Re: Juan Tabo Library, 3407 Juan Tabo NE
Request for Certificate of Occupancy- Transportation Development
Architect's Stamp dated 05-27-2015 (G21-D020)
Certification dated 03-11-16

Project Title: Juan Tabo Library Community Room Addition & Renovation Building Permit #: 2015 9 0720 City Drainage #: G21D020
DRB#: not applicable EPC#: not applicable Work Order#: _____
Legal Description: Track K of the La Reina De Los Altos Subdivision, Unit Two
City Address: 3407 Juan Tabo Blvd NE Albuquerque, NM 87111

**RE: Juan Tabo Library, 3407 Juan Tabo Blvd., NE
Grading and Drainage Plan
Engineer's Stamp Date 3-18-2015 (File: G21-D020)**

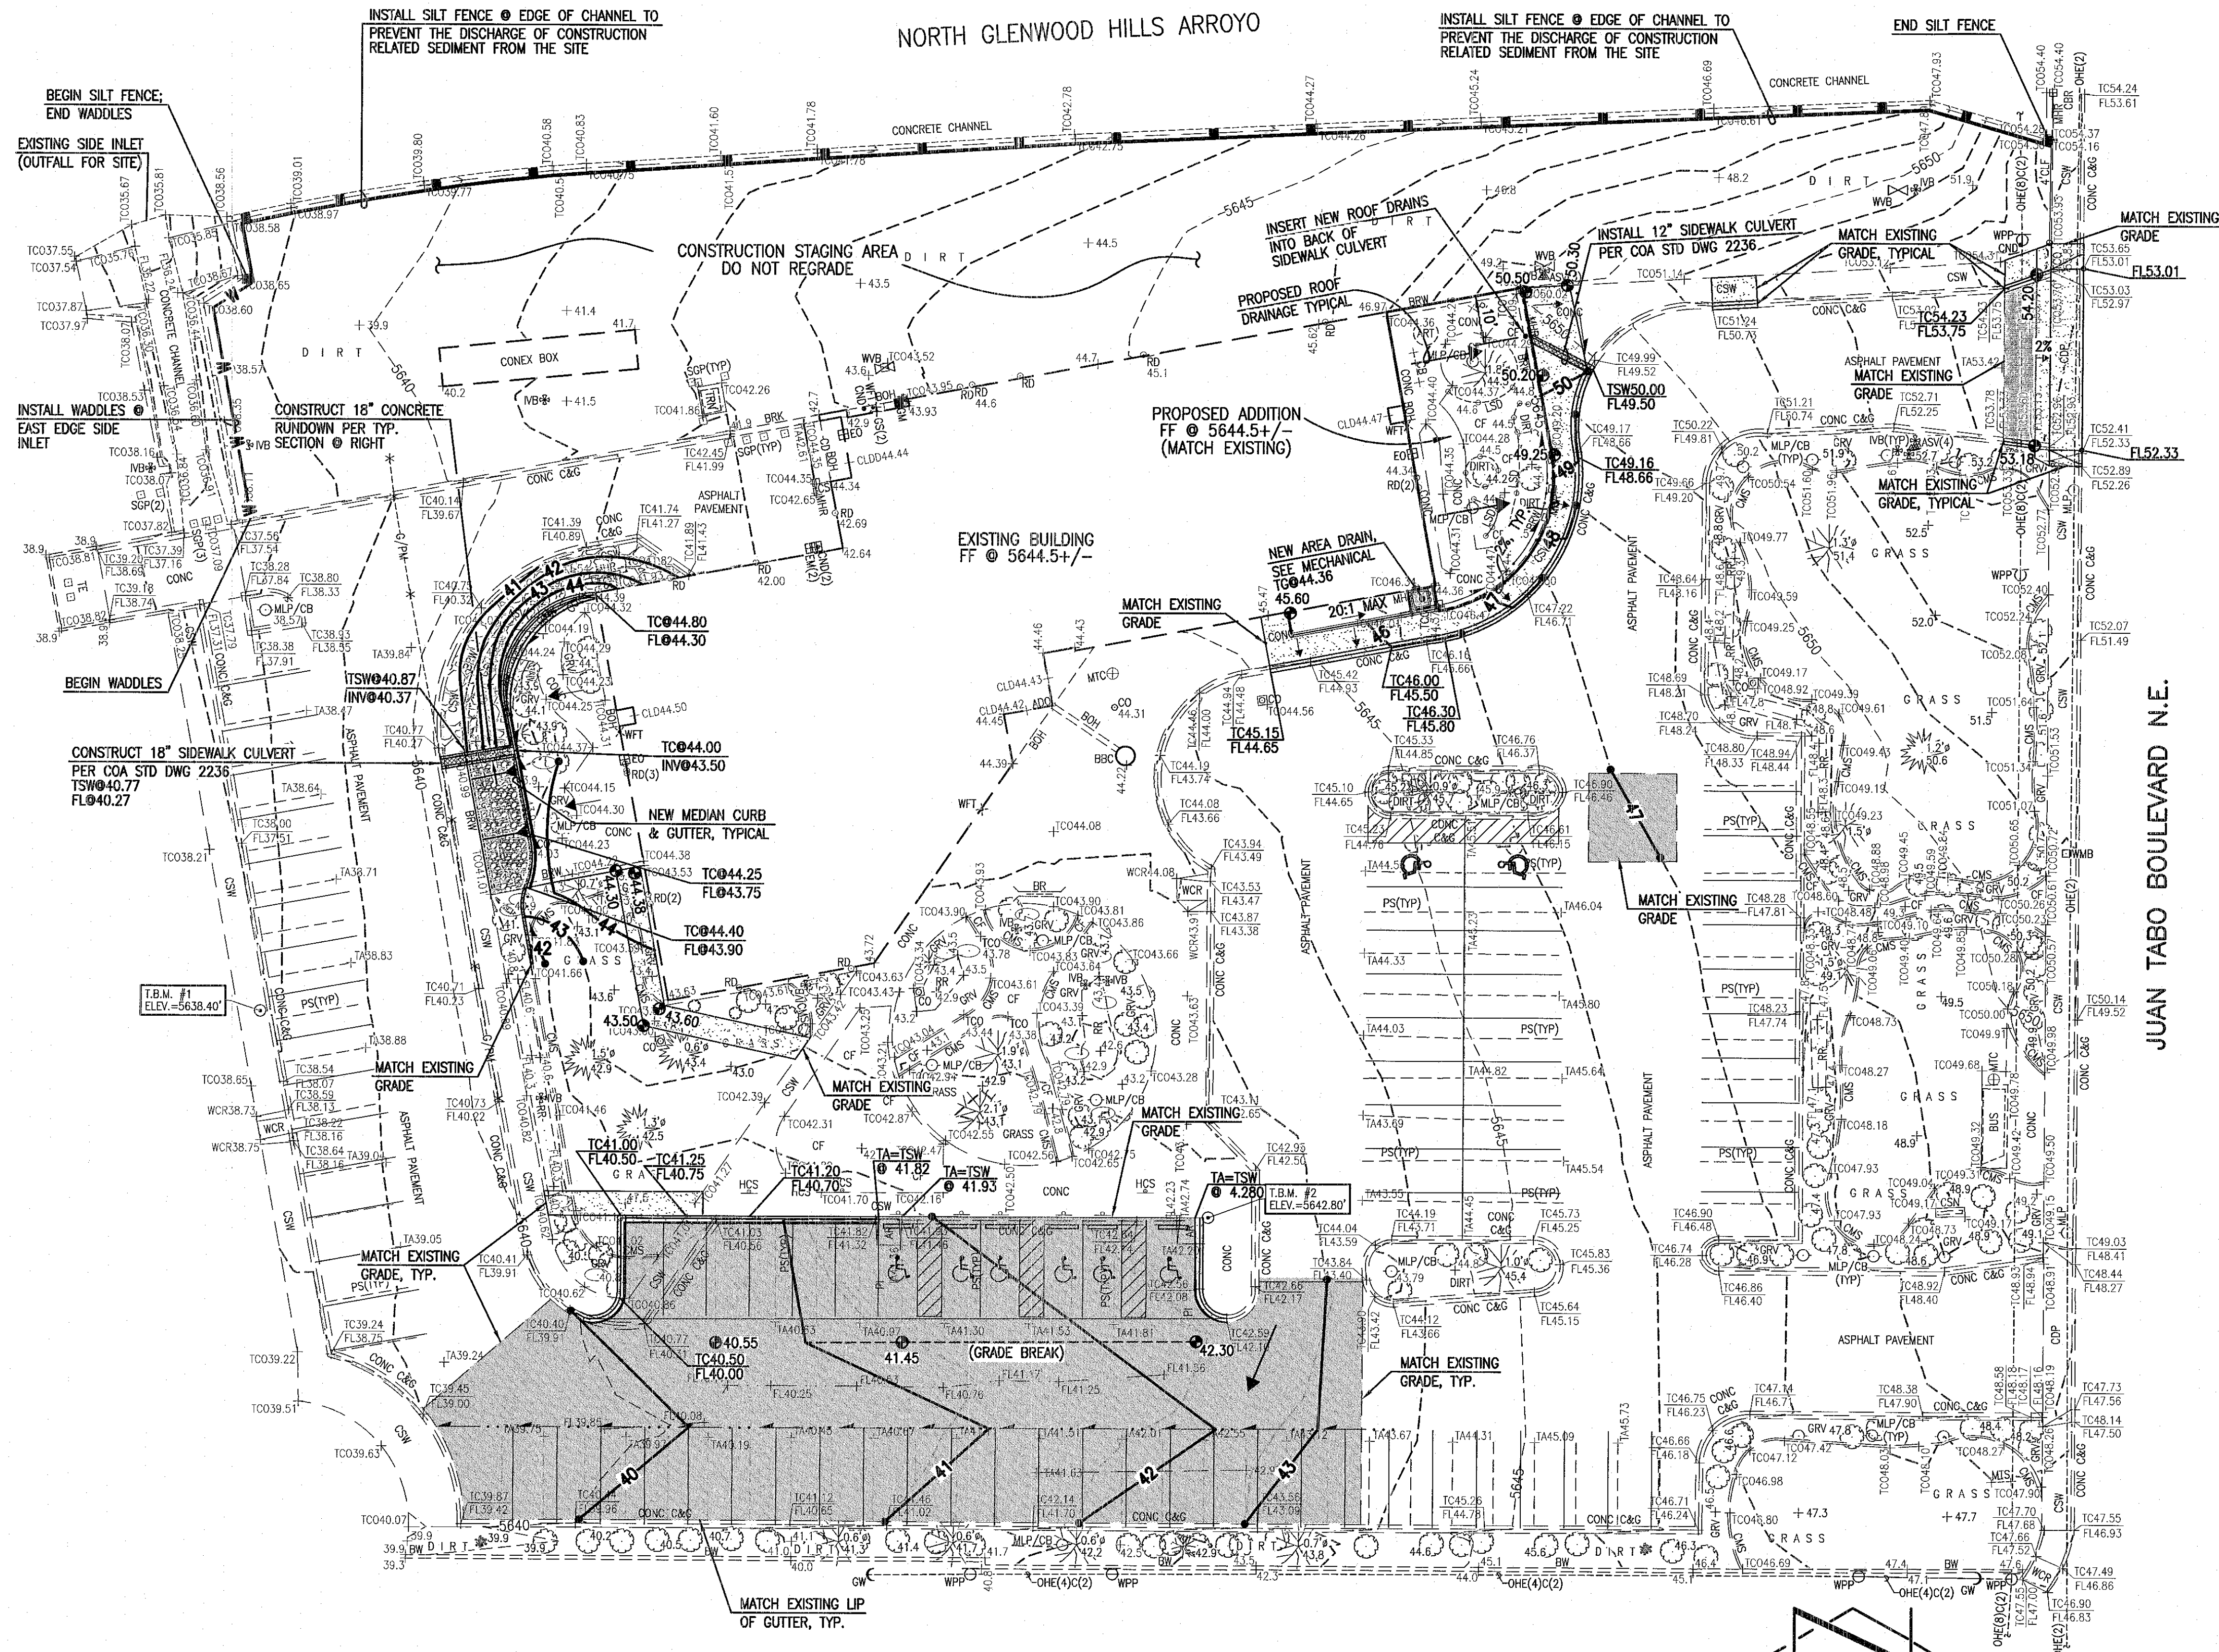
- 1) Label the area of the new building addition on the plan which should equal the added impervious area to the site. As a result of the added impervious area, address first flush management as required per the COA Drainage Ordinance which is defined as 0.34" times the impervious area.
- 2) For the proposed slopes that appear to be steeper than 3:1 along the northwest corner of the building, provide erosion protection.
- 3) For the access onto Juan Tabo Blvd., there is an elevation of 54.20 on the north side of the access that appears as though it should be labeled as a top of curb elevation. Please clarify. Also indicate whether the 53.18 elevation on the south side of the access is a top of curb or flowline elevation.
- 4) Due to the site's direct discharge into the arroyo, obtain a letter of concurrence from AMAFCA.
